Access Report

Date of Report: 18 April 2012

Re: Miranda Dental Hospital – 84-86 Kiora Rd Miranda

Assessment: Plans dated: 17/04/2012

PARKING PROVISIONS:

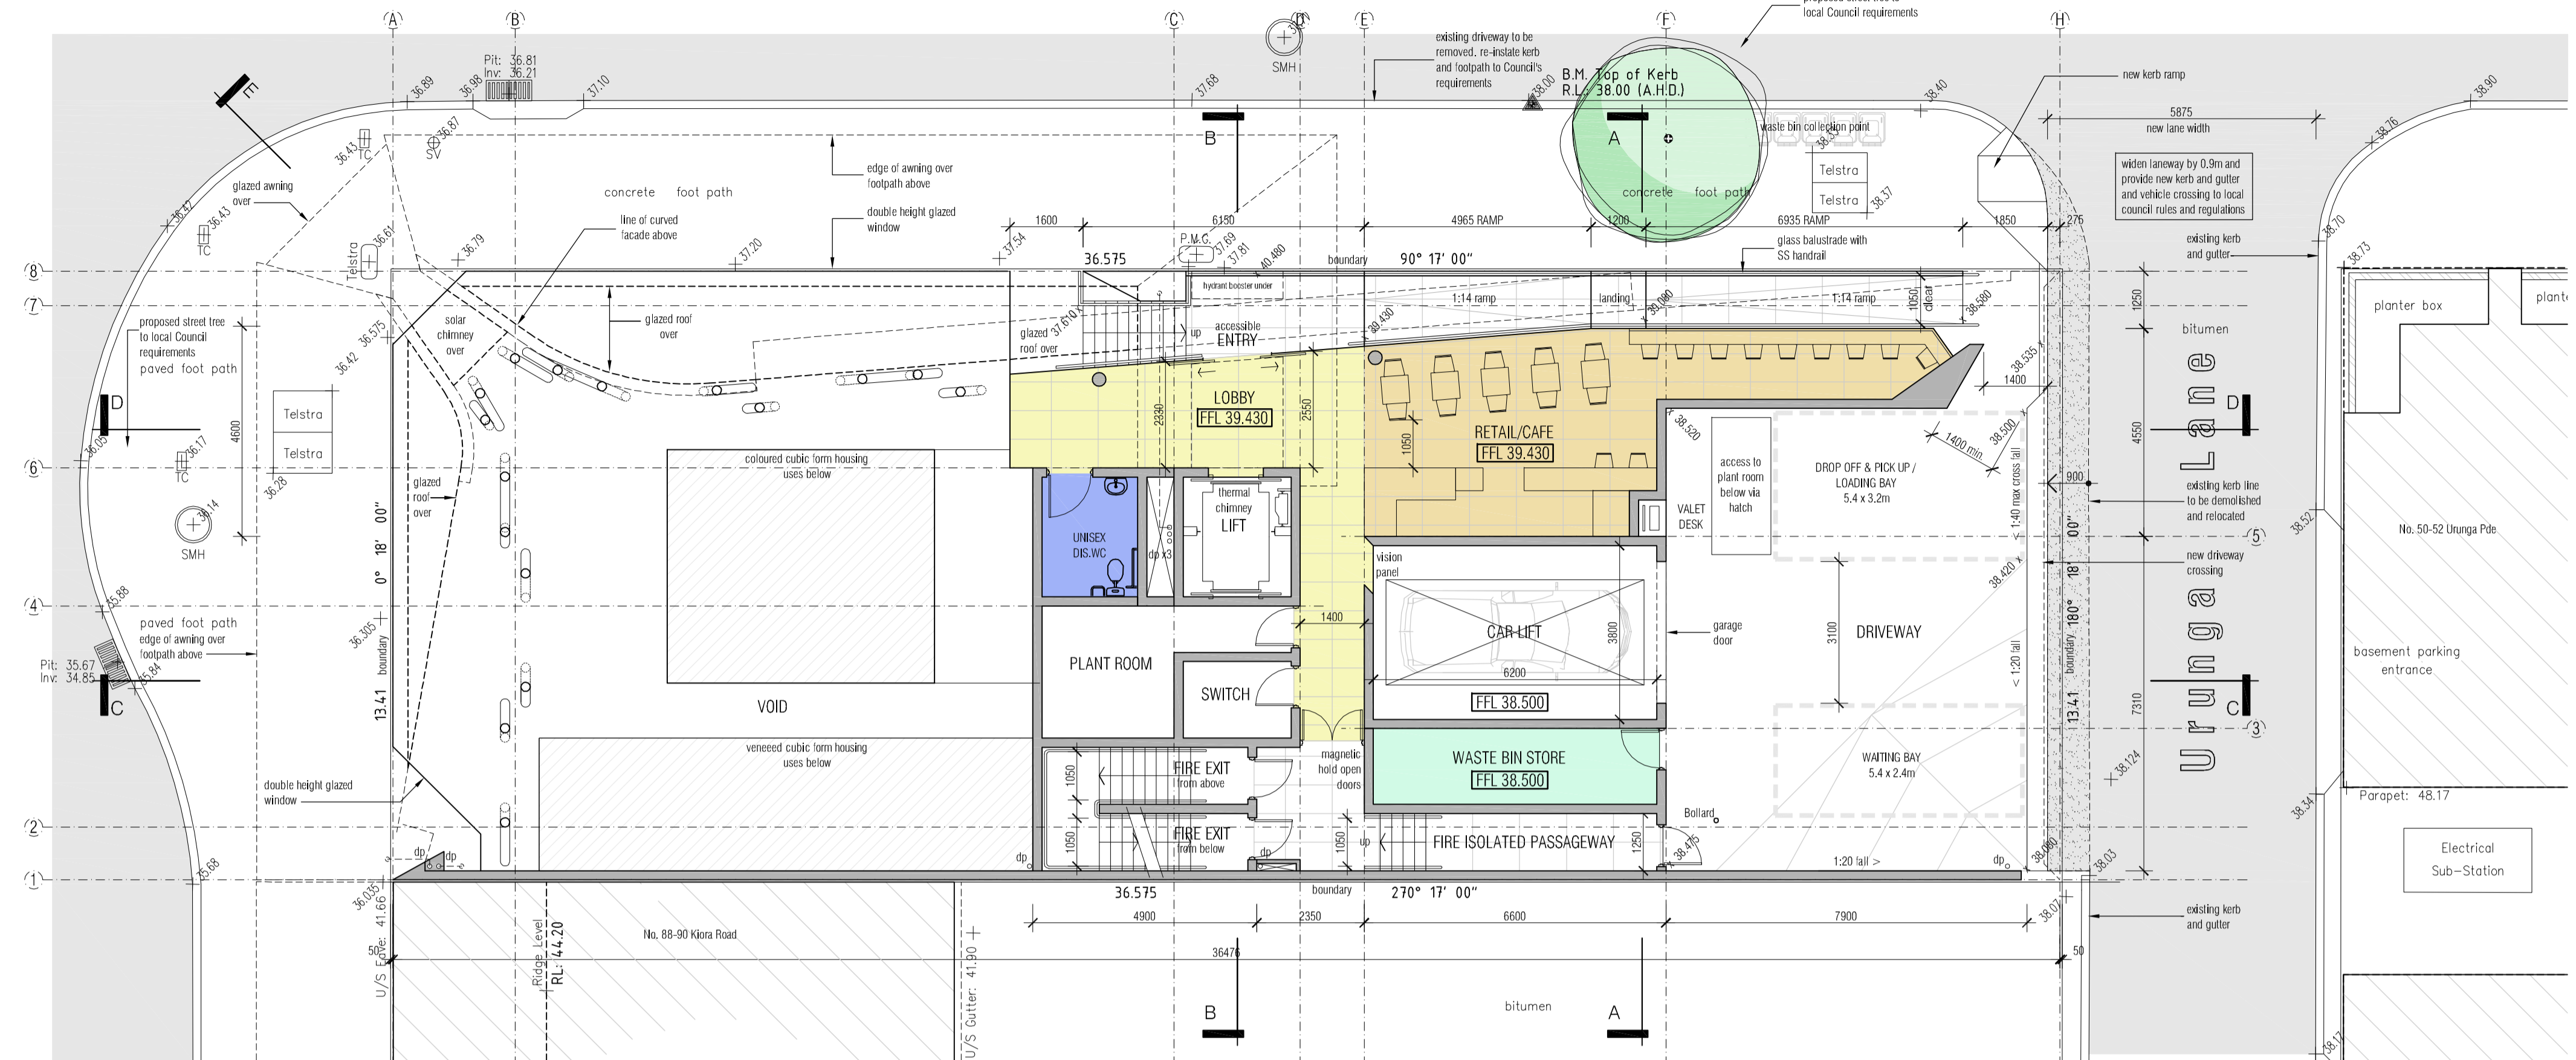
Access elements		Reference	Re: Plans
6. Lift			
6.1	<p>A passenger lift is shown to provide an accessible path of travel to each level (excluding the basement car park which the concierge staff will access via the car lift). It must not rely on a constant pressure device for its operation and is required to have accessible features including:</p> <ul style="list-style-type: none"> a) Handrail complying with AS 1735.12. b) Lift floor dimensions of at least 1400mm x 1600mm. c) Minimum clear door opening of 900mm (AS 1735.12). d) Passenger protection system complying with AS 1735.12. e) Lift landing doors at upper landings. f) Lift car and landing control buttons complying with AS 1735.12. g) Lighting complying with AS 1735.12. h) Automatic audible information within the car to identify the level each time the lift stops. i) Audible and visual information at each lift landing to indicate the arrival of the lift. j) Emergency hands-free communication including a button that alerts a call centre of a problem and a light to signal that the call has been received. 	<p>BCA E3.6 BCA Table E3.6 b</p>	<p>Not fully detailed on plans</p>

LOWER & UPPER GROUND FLOOR PLANS

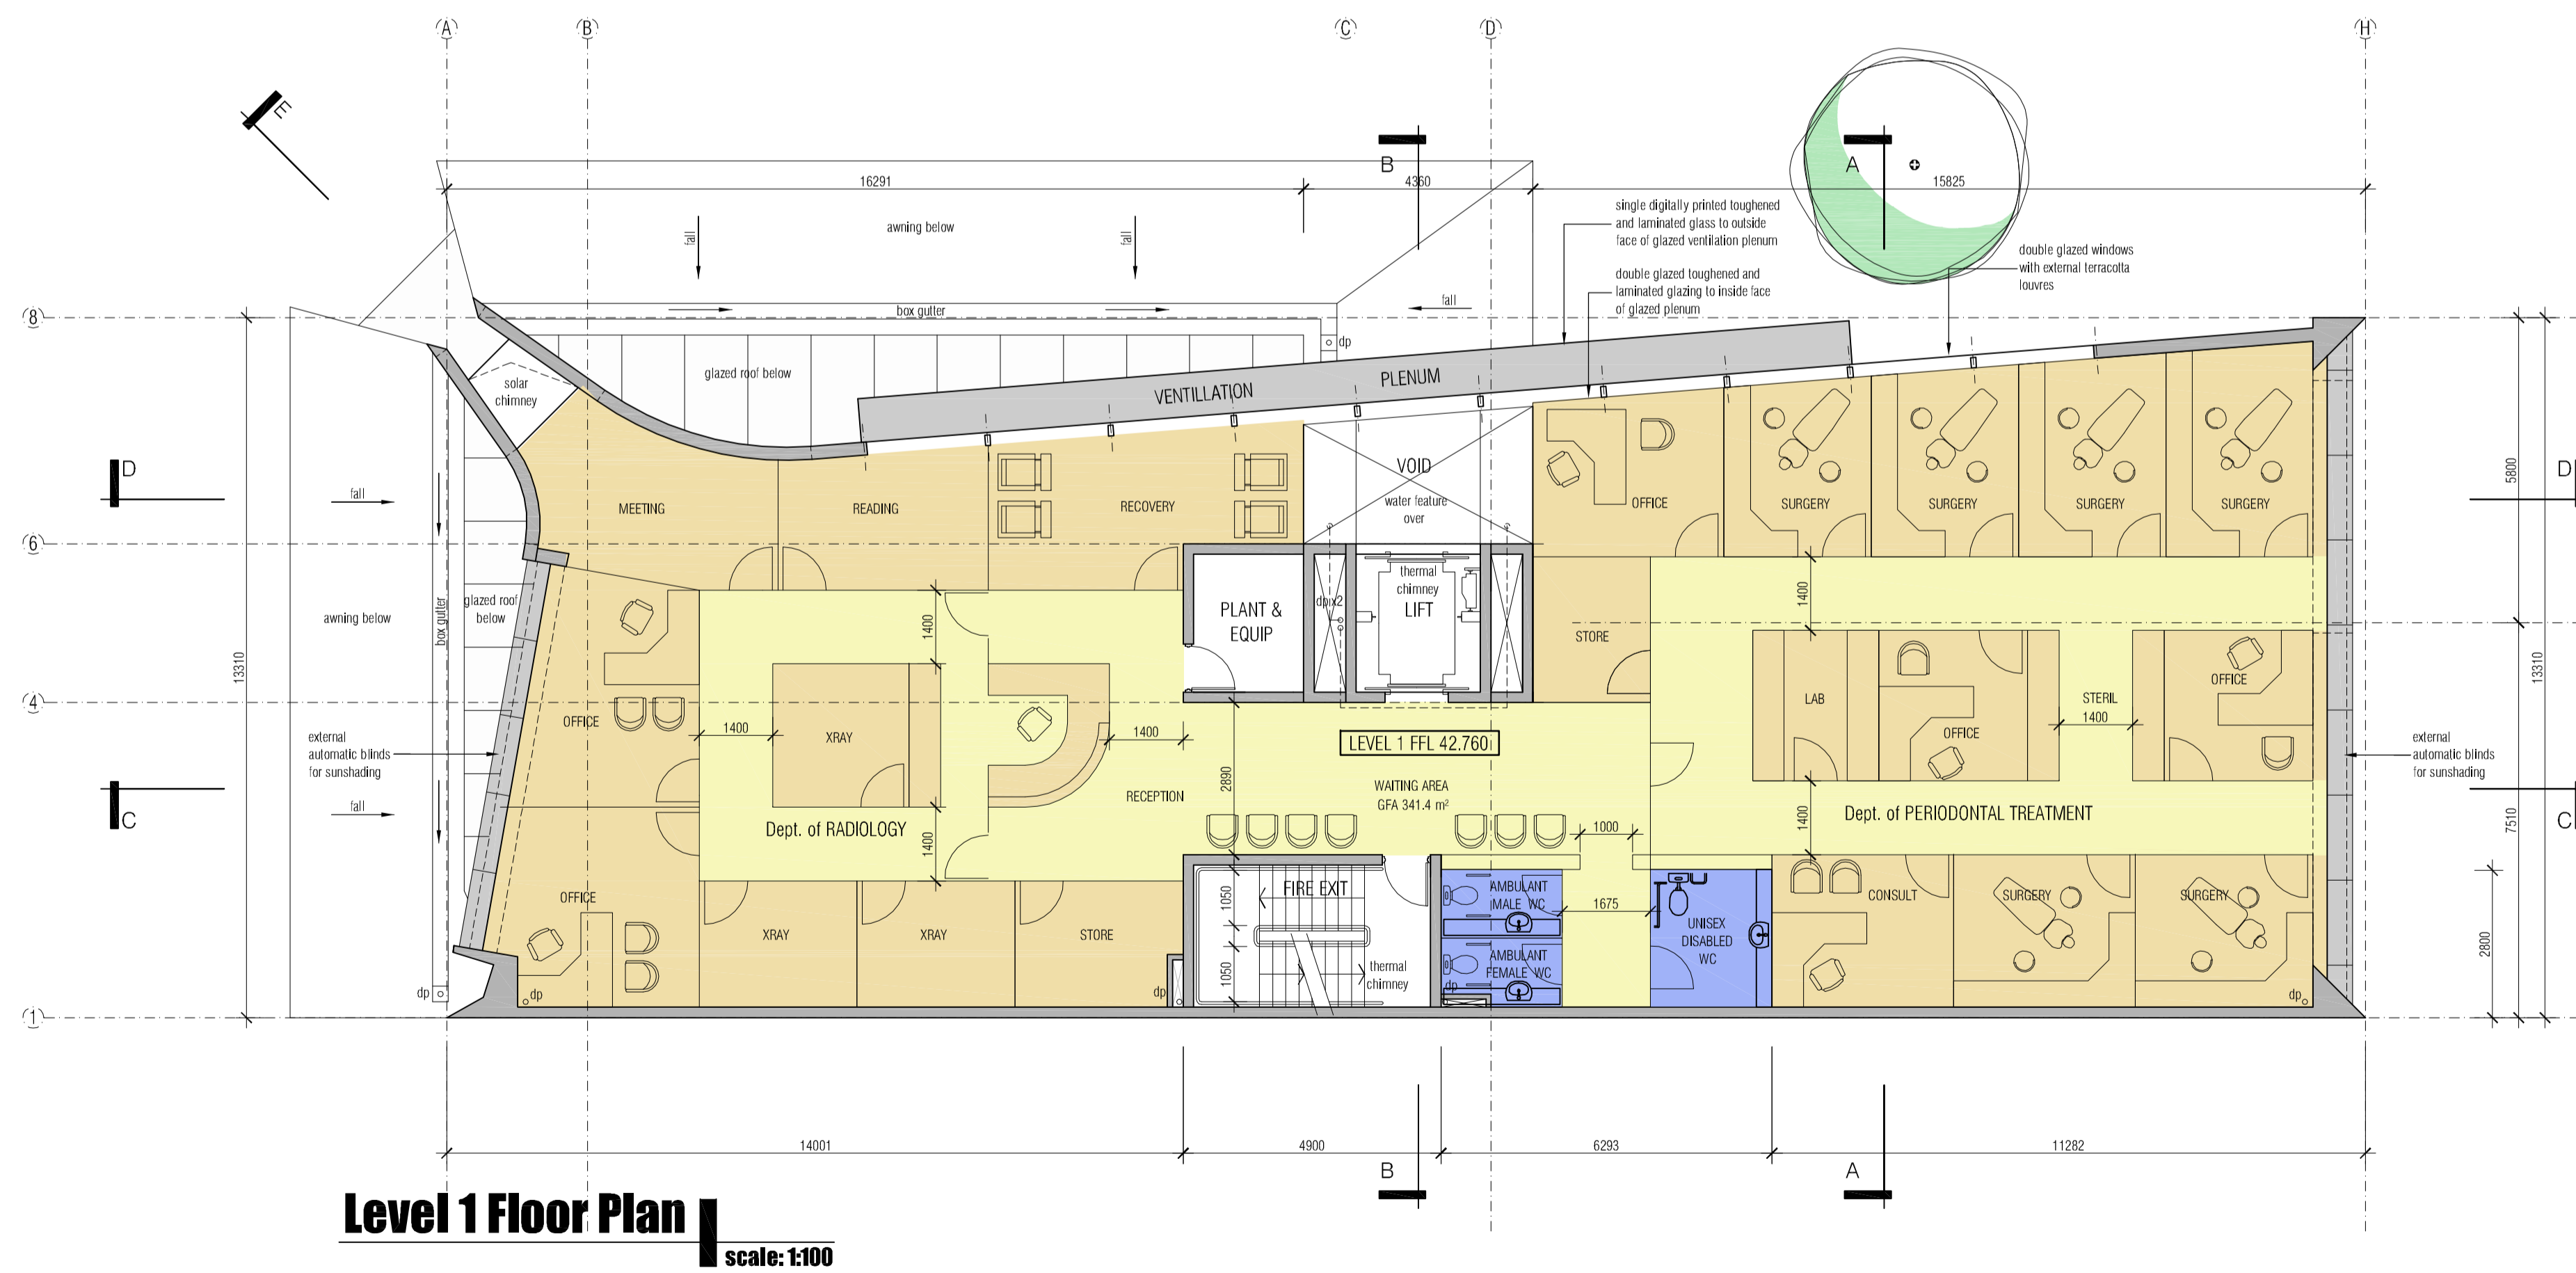
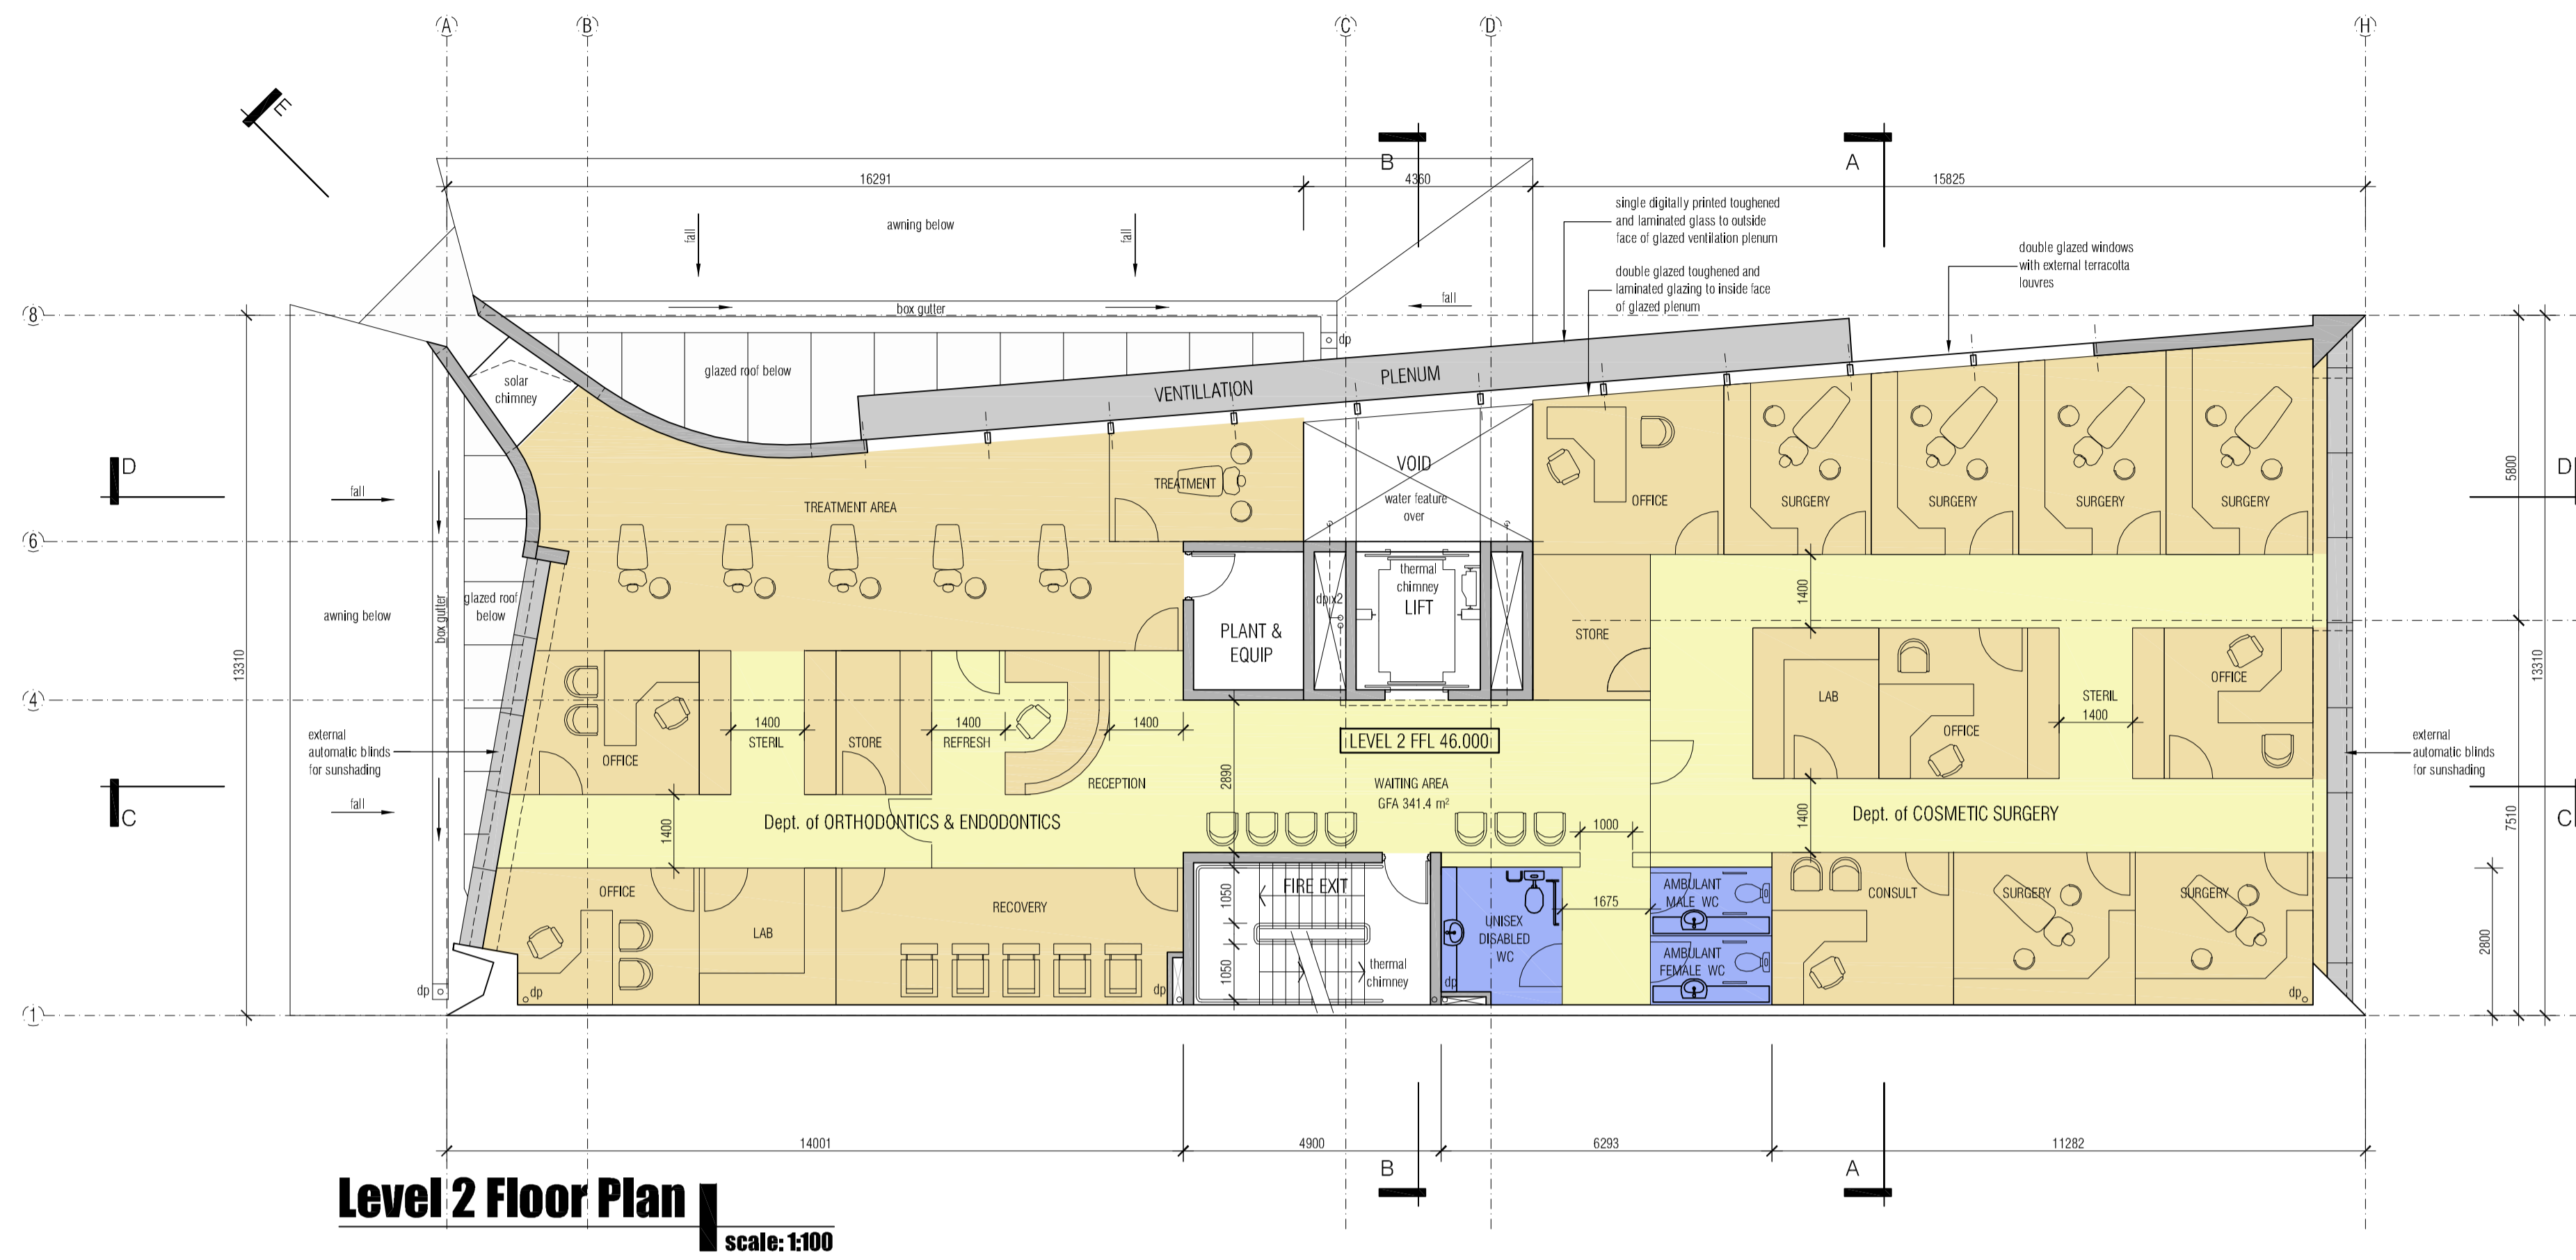
3.1	A 1:14 ramp with adequate landing space is shown providing access to the upper ground level from the car parking set-down area and the street level. This ramp is to comply with AS 1428.1 including the following features:	BCA D3.3 a	Not fully detailed on plans
	a) Sharp transitions are to be provided between the planes of landings and ramps.	AS 1428.1 10.1 a	
	b) The gradient is to be constant throughout its length (a construction tolerance of 3% is allowed provided no section is steeper than 1:14).	AS 1428.1 10.3 a, b	
	c) Handrails are required on both sides of ramps.	AS 1428.1 10.3 e	
	d) Kerbs or kerb rails are required on both sides of the ramp (the wall adjacent to the ramp may serve as the kerb if located within 100mm of the ramp-side face of the handrail).	AS 1428.1 10.3 i, j

Access elements		Reference	Re: Plans
e) Tactile ground surface indicators are required at the top and bottom of the ramp.		BCA D3.8 a iv	Not shown on plans

3.2	Stairs are shown at the entry on the corner of Urunga Parade and Kiora Road. Stairs are also shown off Urunga Road to approach the upper ground level entry. These stairs are required to have accessible features complying with AS 1428.1 including:	BCA D3.3 a	Not fully detailed on plans
